MMC Trip Distribution

Fri, Apr 27, 2018 at 12:38 PM

We have had a chance to take a look at the trip distribution. Here are our comments:

Existing Employee Garage Trip Assignment

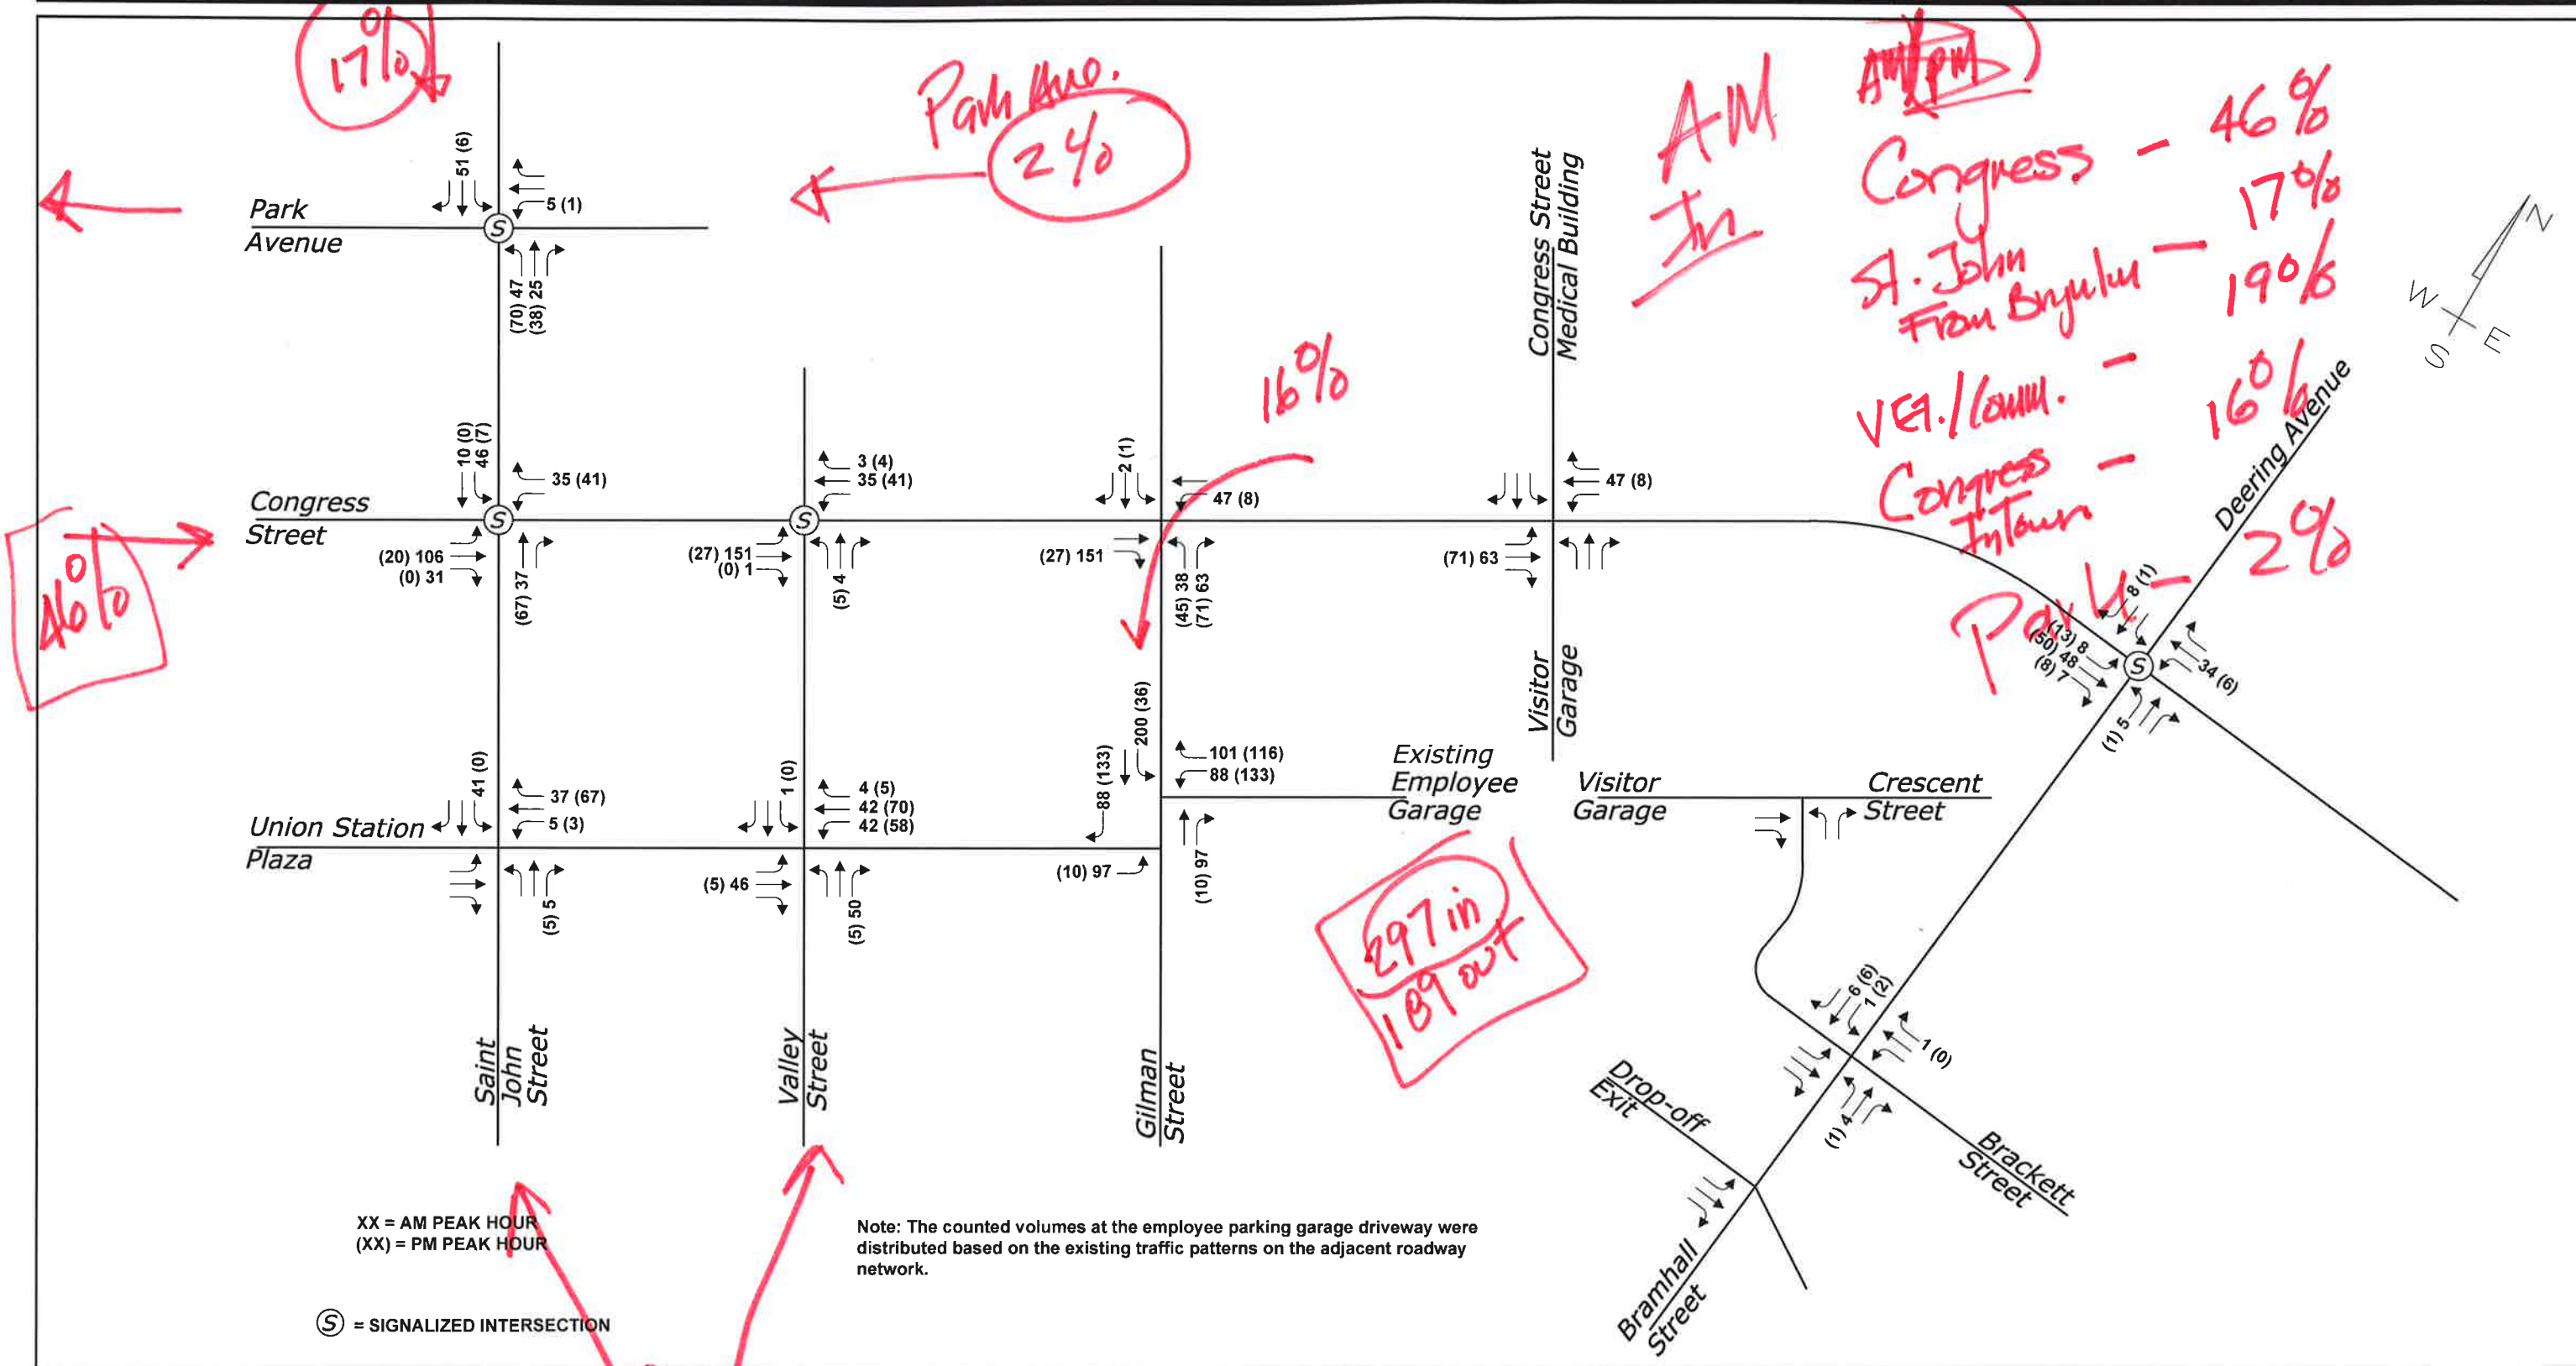
GPCEI previously provided an Existing Employee Garage Trip Assignment estimate for the AM and Peak hours. This was based upon a traffic count at the existing garage and turning movement volumes at nearby intersections. The approximate outcome is noted below:

- a. During the AM peak hour the following inbound assignment was estimated:
 - Congress Street from west – 46%
 - St. John Street/Valley Street (VMB and outbound Commercial) – 19%
 - Park Avenue WB to St. John Street – 2%
 - Congress Street from east to Gilman Street – 16%
 - Brighton Avenue via St. John Street – 17%
- b. During the PM peak hour the following outbound assignment was estimated:
 - Park Avenue to the west – 28%
 - St. John Street/Valley Street (VMB and inbound Commercial) – 25%
 - Gilman to Park Avenue EB – 29%
 - St. John Street to Brighton Avenue – 15%

Based upon the above, we would suggest that the two sets of information be merged in the development of a final assignment. In general, the VHB regional travelshed methodology seems reasonable. What is not clear is how motorists will route to the travelshed areas, particularly in the vicinity of MMC. Some notable discrepancies:

- Congress Street inbound from the west approaching St. John – 23% vs. 46%
- Brighton Avenue – 28% vs. 17% in AM and 15% in PM

VHB Travelshed Analysis

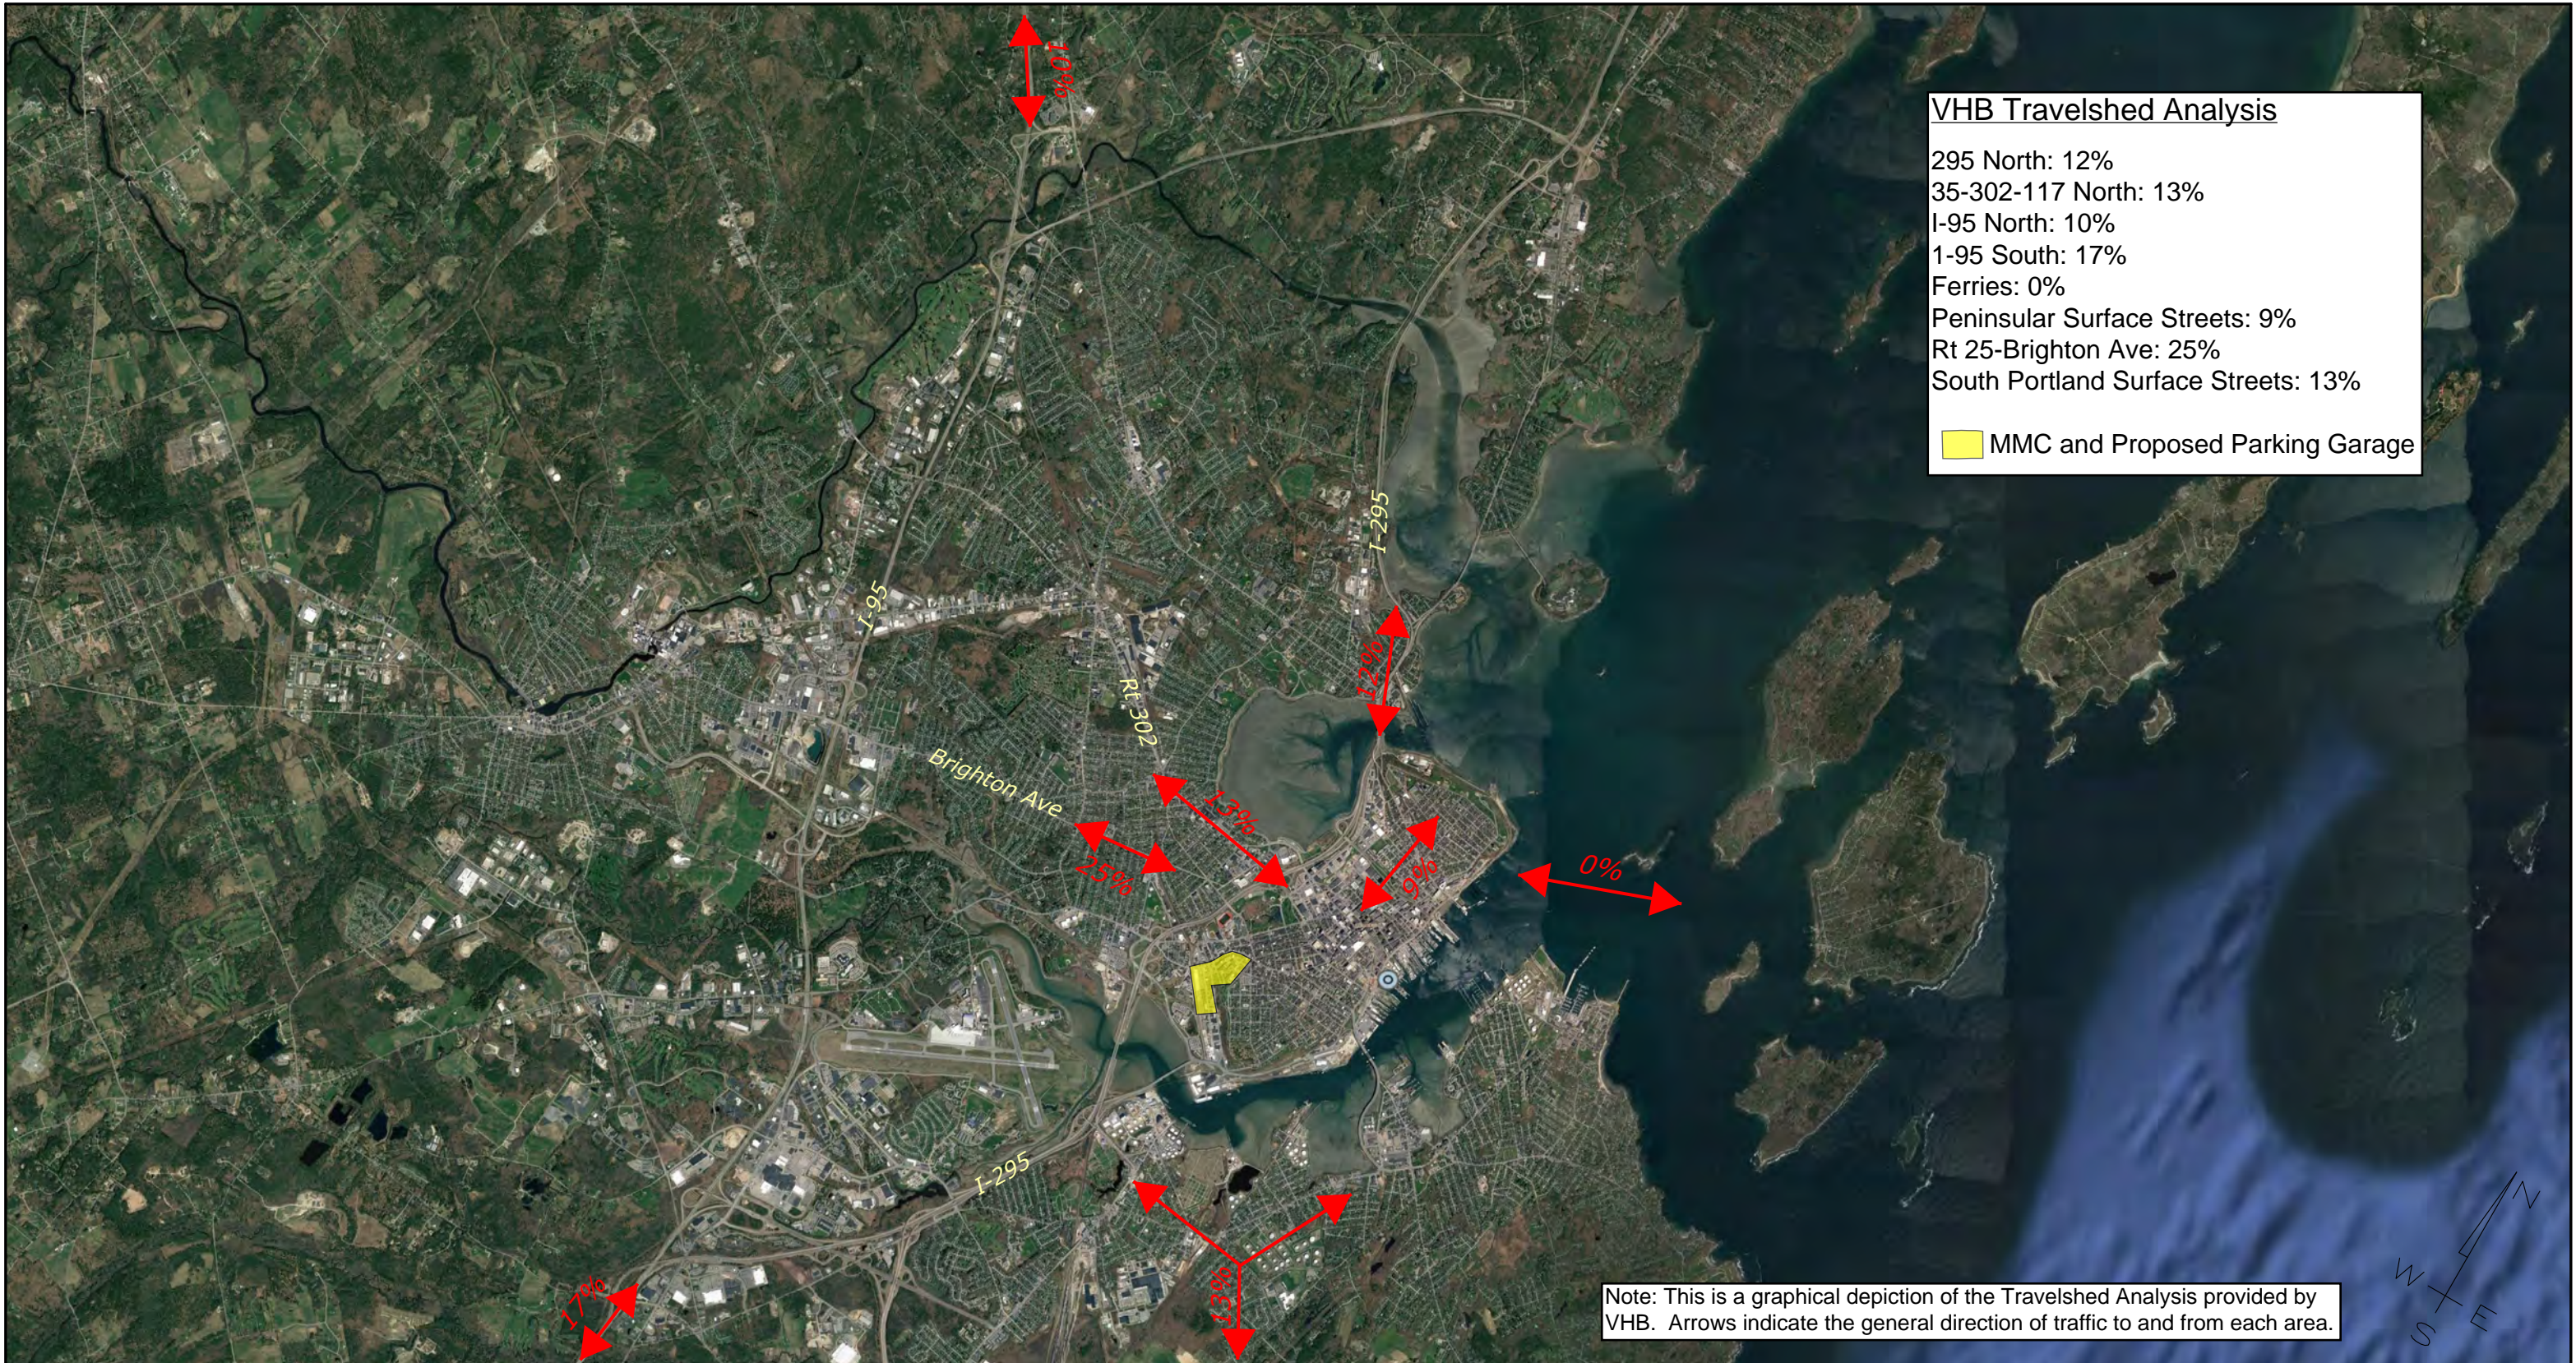
1. Can you provide an explanation as to whether/how VHB calibrated the travelsheds with actual employee travel surveys?
2. The percentages for trip assignment based on the travel sheds would appear to generally make sense, although they are likely somewhat conservative for the major in-town routes, as travelers will use any number of methods to accomplish what they feel is an optimal travel pattern. Can you speak to this concern?

4. The regional assignment of trips closely matches the VHB Employee Travelshed analysis with the following conclusions:
 - a. 17% of the trips are from I-95 (from the south). **[VHB estimated 17%]**
